Your Reference SSD-77260958
Michelle Niles
Department of Planning, Industry and Environment
Via Major Projects Planning Portal

23 May 2025

**Submission to SSDA
20-24 Railway Parade and No.2-4 Burleigh Street, Burwood
Mixed Use Development**

1 BASEMENT LEVELS 4-5 - RESIDENTIAL PARKING
1:200

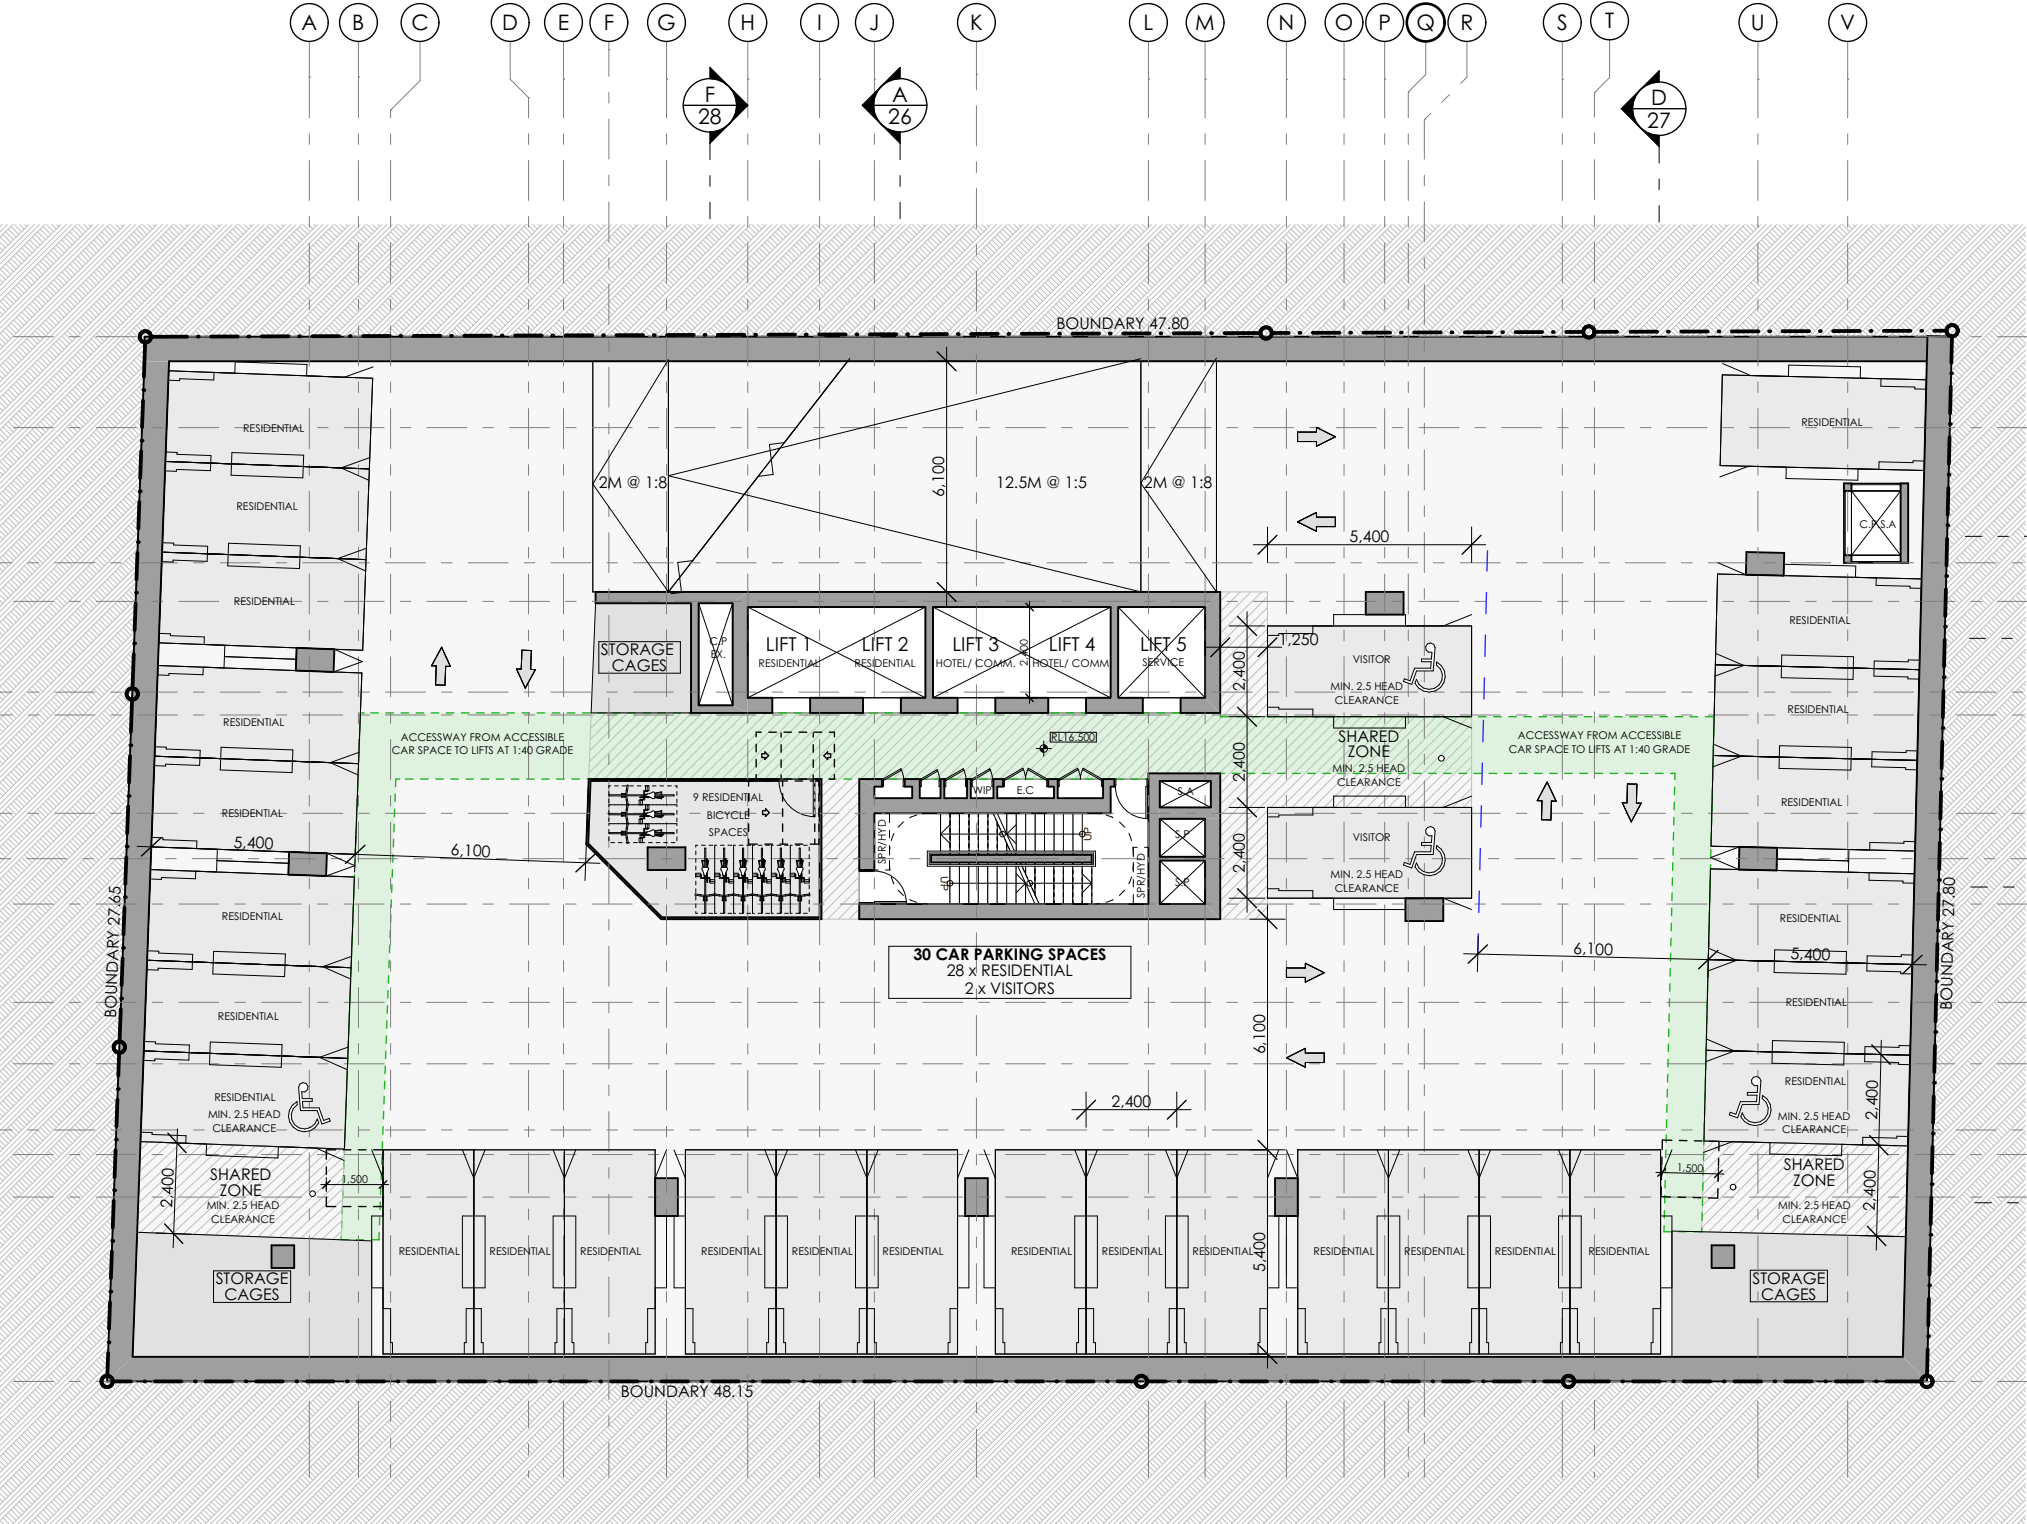
Design drawings SK08 P24, SK09 P24 and SK10 P24 do not show bollards in the shared space adjoining the accessible parking (allocated) space. In addition, dimensions are not shown for the accessible parking spaces (across all basement levels).

1 BASEMENT LEVEL 1 - HOTEL/ COMMERCIAL PARKING
1:200

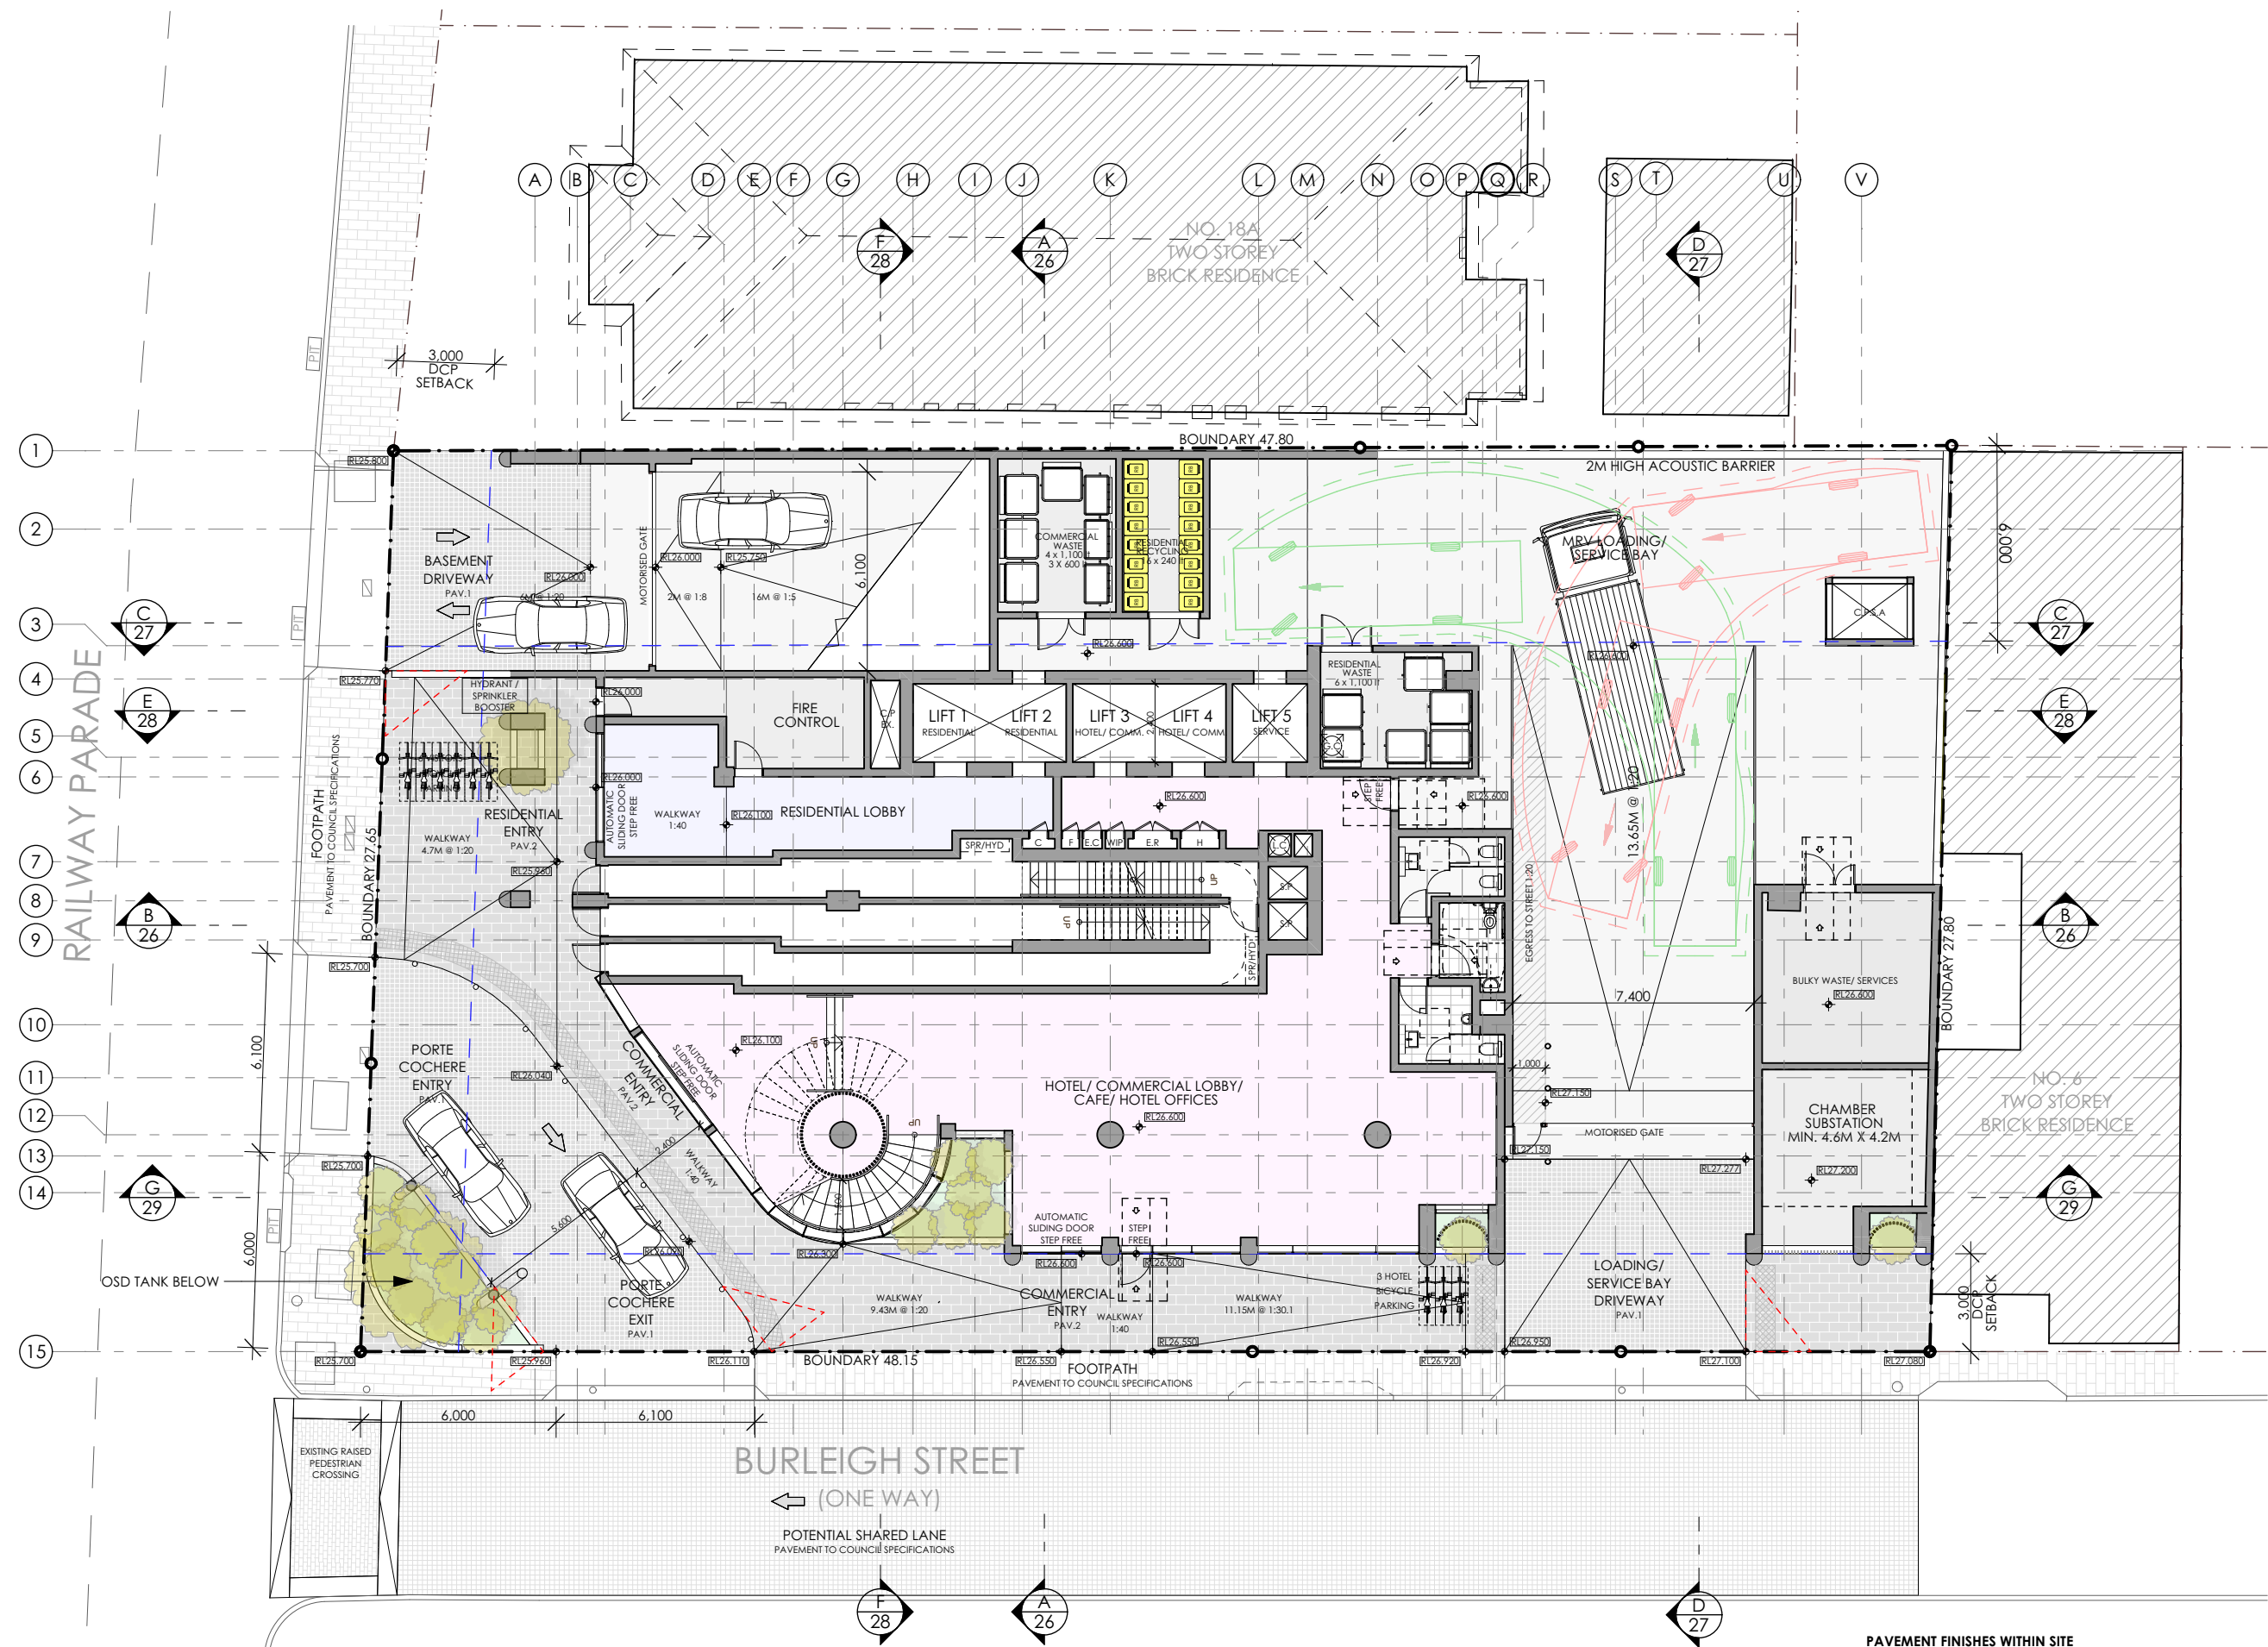
On drawing SK10 P24, there appears to be a substation pit above the accessible parking space. Recommendation for services designer/engineer to consider relocation of this pit. Otherwise, the construction of this space must be in accordance with AS2890.6-2022 – car parking spaces for disabilities

Basement 1-shared space for accessible parking space (eastern end of basement) is adjacent to a main switch room with two outward opening doors. It would be difficult to utilise this space with the first door being an additional obstruction in close proximity to a support pillar

Recommendation: Reconsider locations of all bulky goods storage. Reconsider the siting of

doorways to each storage and review the actual door width. The door widths are not compatible with the bulky goods storage – refer to Basement 1 drawing SK10 P24 (below) with double doors exceeding 850mm.

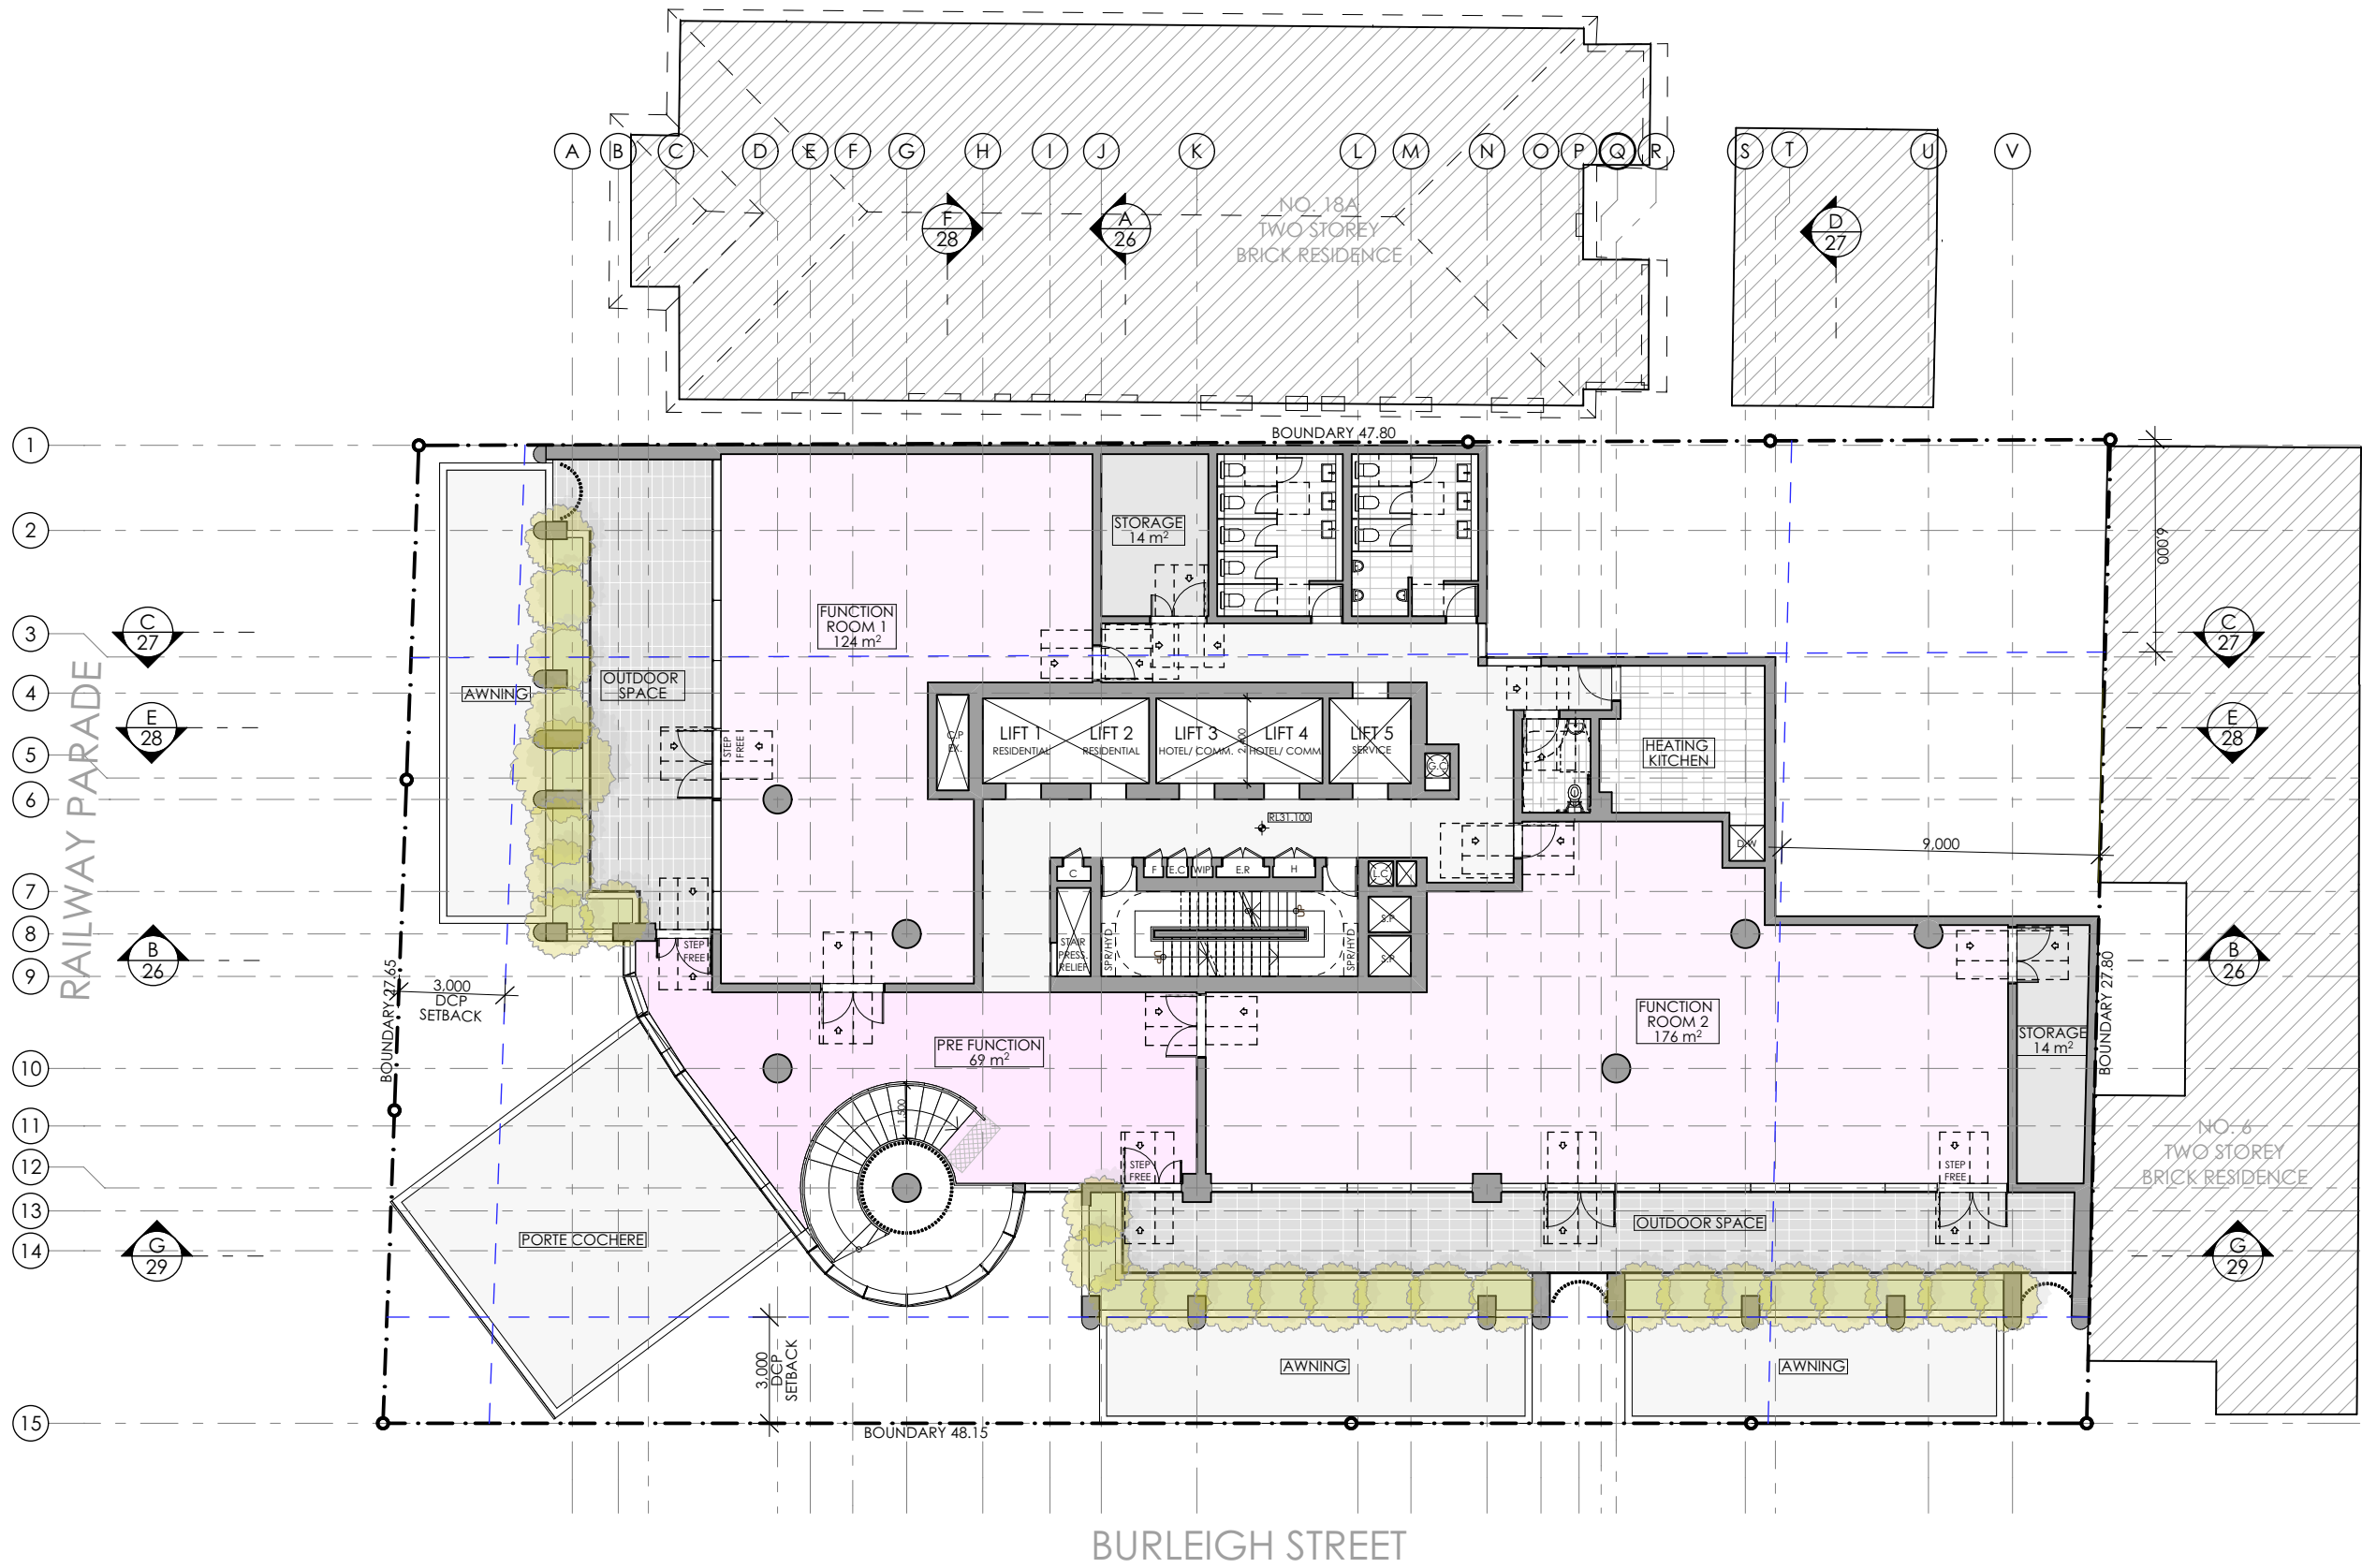
Ground floor level consists of residential access lobby, hotel and commercial offices lobby and supposedly a café (cannot identify location of café from drawing SK11 P24). Certifier to consider appropriate classification of each part of the building, and to make an assessment under NCC 2022 on fire safety.

Fire separation for consideration by the certifier – wall between bulk goods storage and the substation. The bulky goods storage (depending on management of access) may contain hazardous goods such as a portable BBQ.
